MEMORANDUM

SUBJECT: SF-21-032– Sterling Ranch Filing No. 3
First Submittal

Engineering Division

**FINAL DRAINAGE REPORT
FOR
STERLING RANCH FILING 3**

**STERLING RANCH PHASE 2 EX. GAS LINE PROFILE
STA 0+00.00 TO 10+78.71**

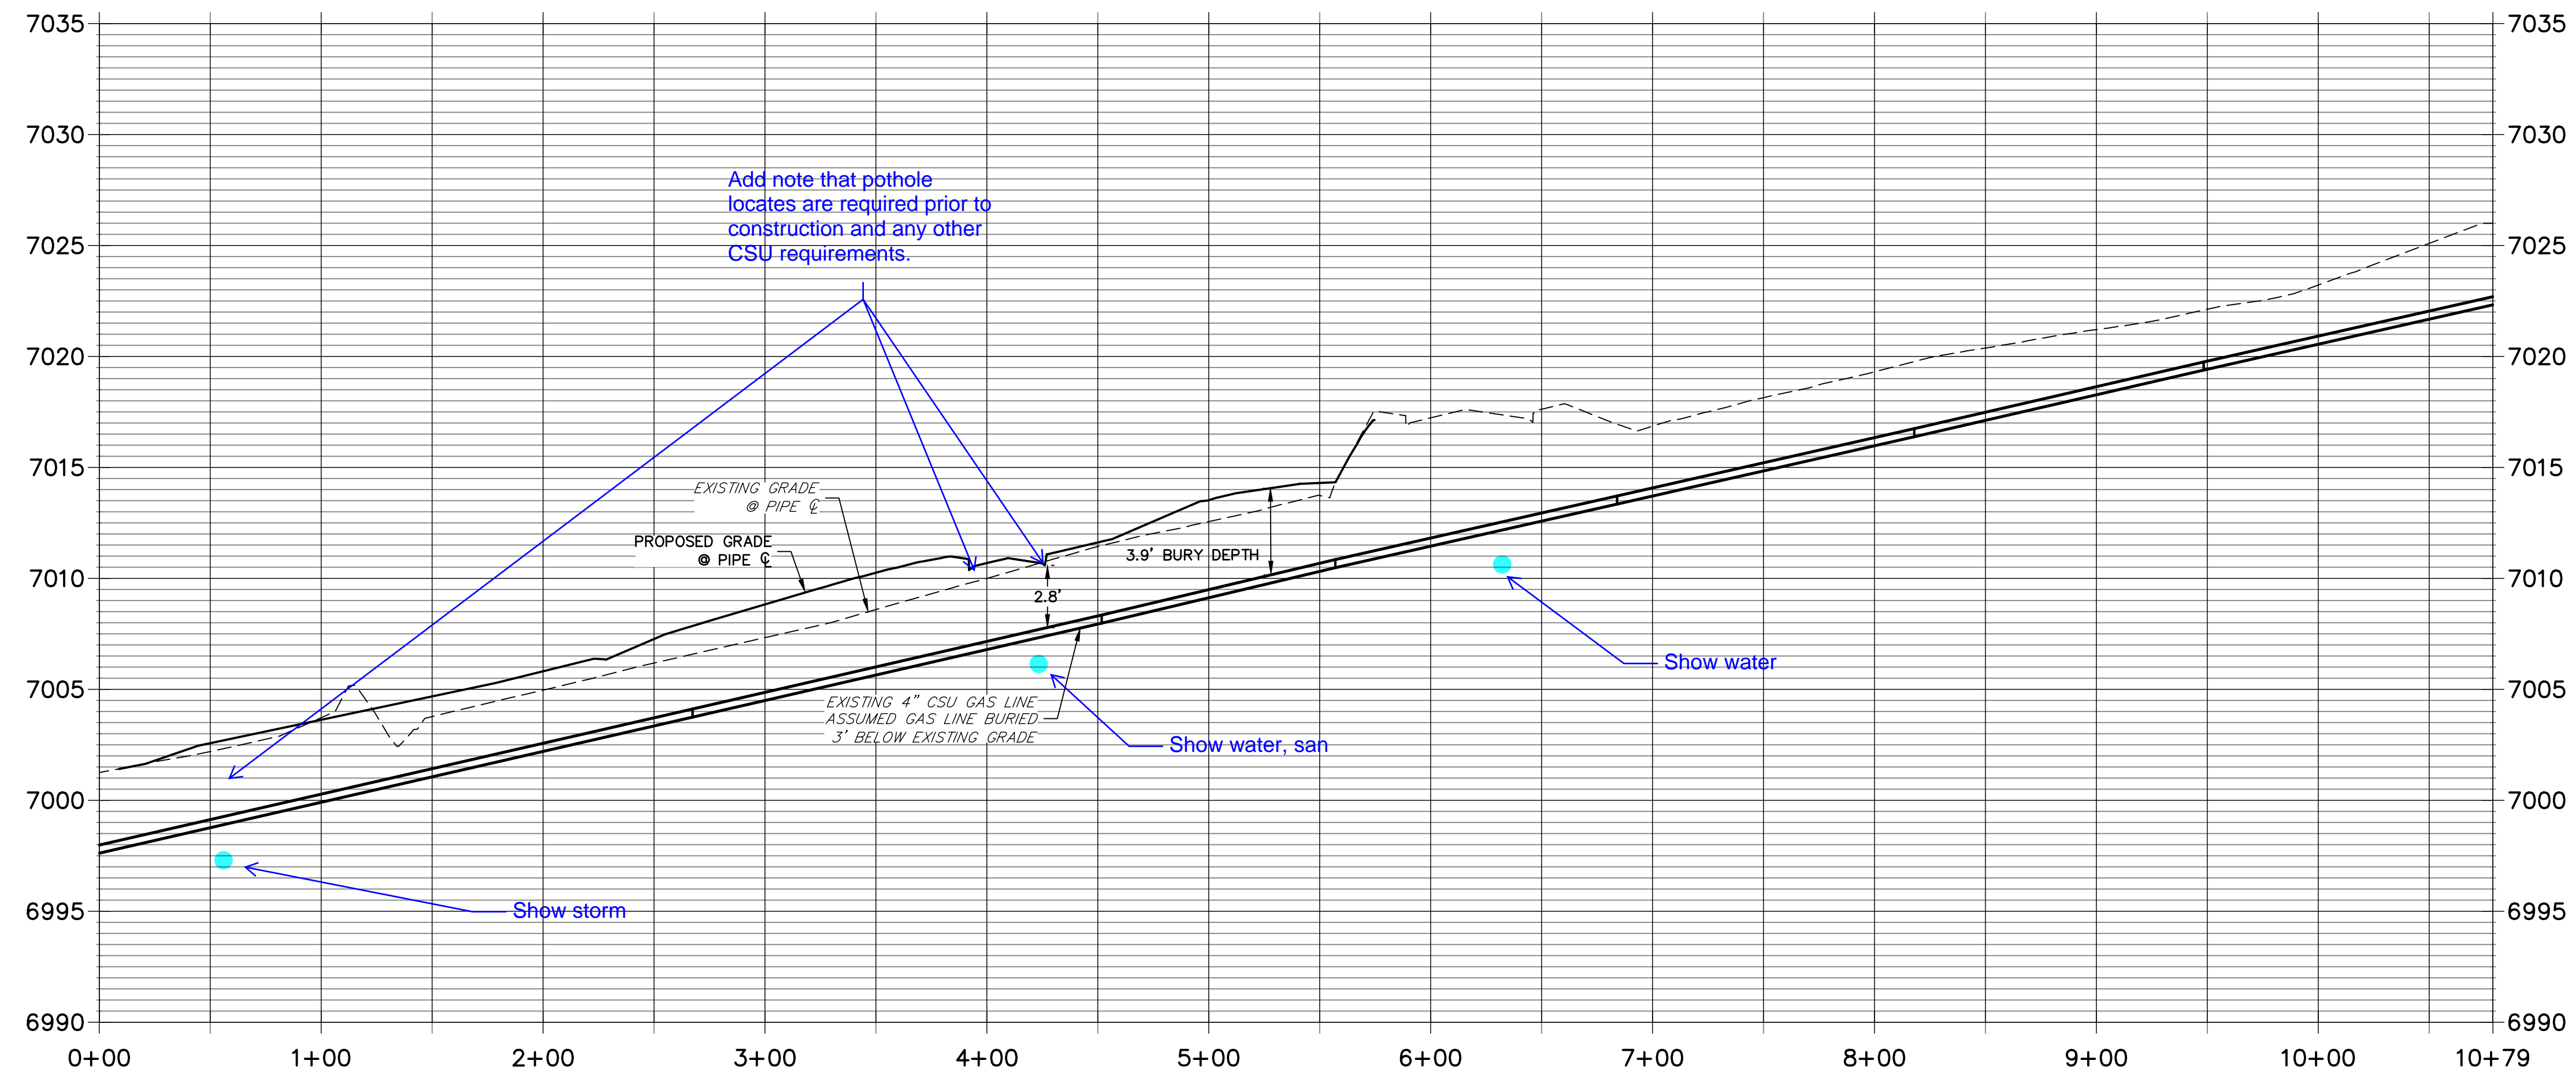
JR Response: Noted
11. Provide an informational profile along the gas main through the plat area showing cover and crossings.
12. JR Response: Addressed, gas profile added
